STATEMENT OF:

DAVID L. ANDERSON PE
9200 SE 57th Street
Mercer Island, WA 98040

Revised Plan Submittal:

SITE PLAN
5637 MERCER WAY
MI TREEHOUSE, LLC
 11030 SE 30TH ST
 BELLEVUE, WA 98004

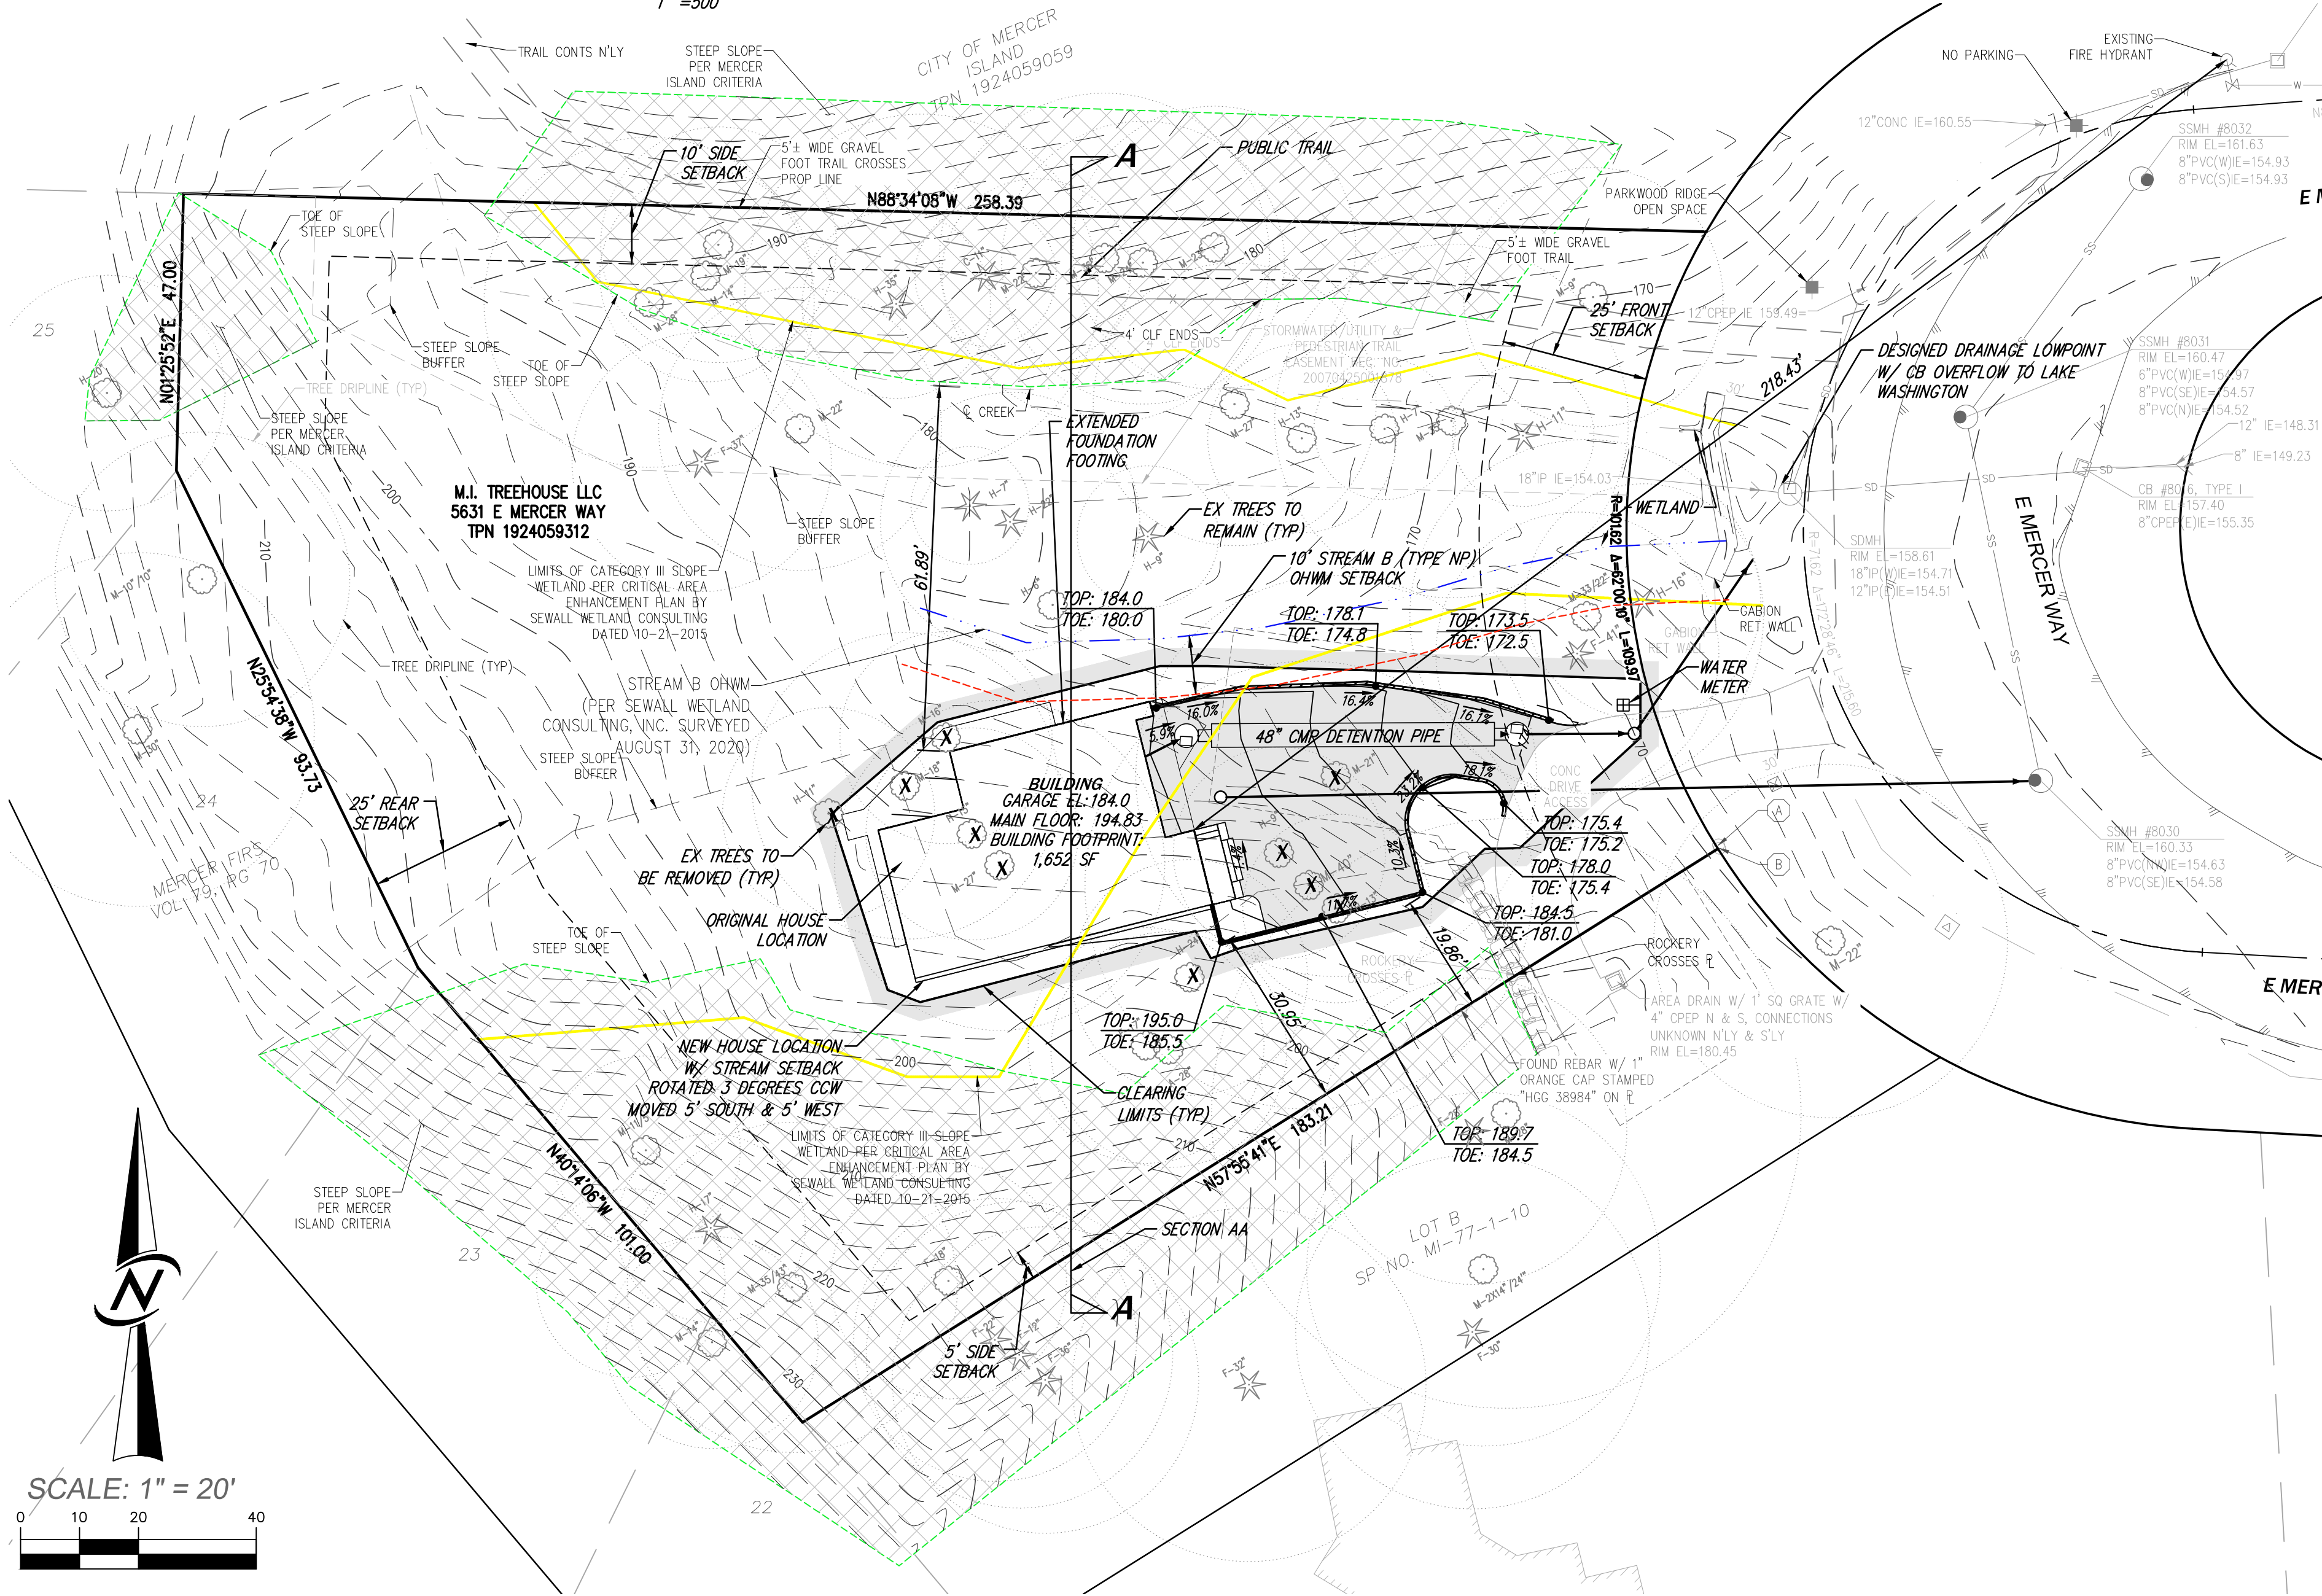
Further, the plan that shows the pile locations incorrectly shows this work occurring directly over the stream location.

The storm water detention pipe and associated drainage structures that have been shown on the plan will require a large excavation to an elevation of 167. This is nearly 9 feet below the existing adjacent stream that is approximately 15 feet away. The depth of this excavation will be 15 feet below the existing grades at the west end of the detention structure. Construction of such a deep storm structure in a sloping wetland within 15' of a stream will certainly have a much wider impact than what is currently delineated on the plan especially considering the presence of saturated soil conditions as the area is a wetland. Further, the geotechnical report shows low blow counts for the soils in this area that corresponds to very soft soil conditions making these excavations potentially significantly larger.

The impacts to the adjacent wetlands for the grading and perforated piping for both the detention system and the foundation drains around the building have still not been addressed and are not accounted for in the plans. These drains will intercept the water that was previously tributary to the adjacent stream and surrounding wetlands and direct it to the piped storm drainage system. Despite our repeated efforts these impacts are not addressed or accounted for in the submittal materials. The only responses to our previous comments are that the impacts will be re-evaluated in the future and that the existing soils "do not appear prone to drainage".

The recommendations included in Section 5.6 of the geotechnical report for drainage is not acknowledged on the site plan or in the tabulated areas of wetland disturbance. This includes a recommendation to slope the ground surface away from the proposed building at a gradient of at least 3% for a distance of at least 10' away from the building for all areas that are not paved. This would include grading and surface impacts to the existing wetland areas south and west of the building site. Use of a drainage matt with a geotechnical fabric as shown on the current plan set in place of positive surface drainage may work in the short term but over time it will lose the ability to convey water as the fabric collects silt and colloidal material. Once this occurs, the area around the walls will need to be re-graded to direct surface water away from the structure. Keep in mind, this flow will be fairly continuous as the walls are located within a sloping wetland that is feeding the adjacent stream.
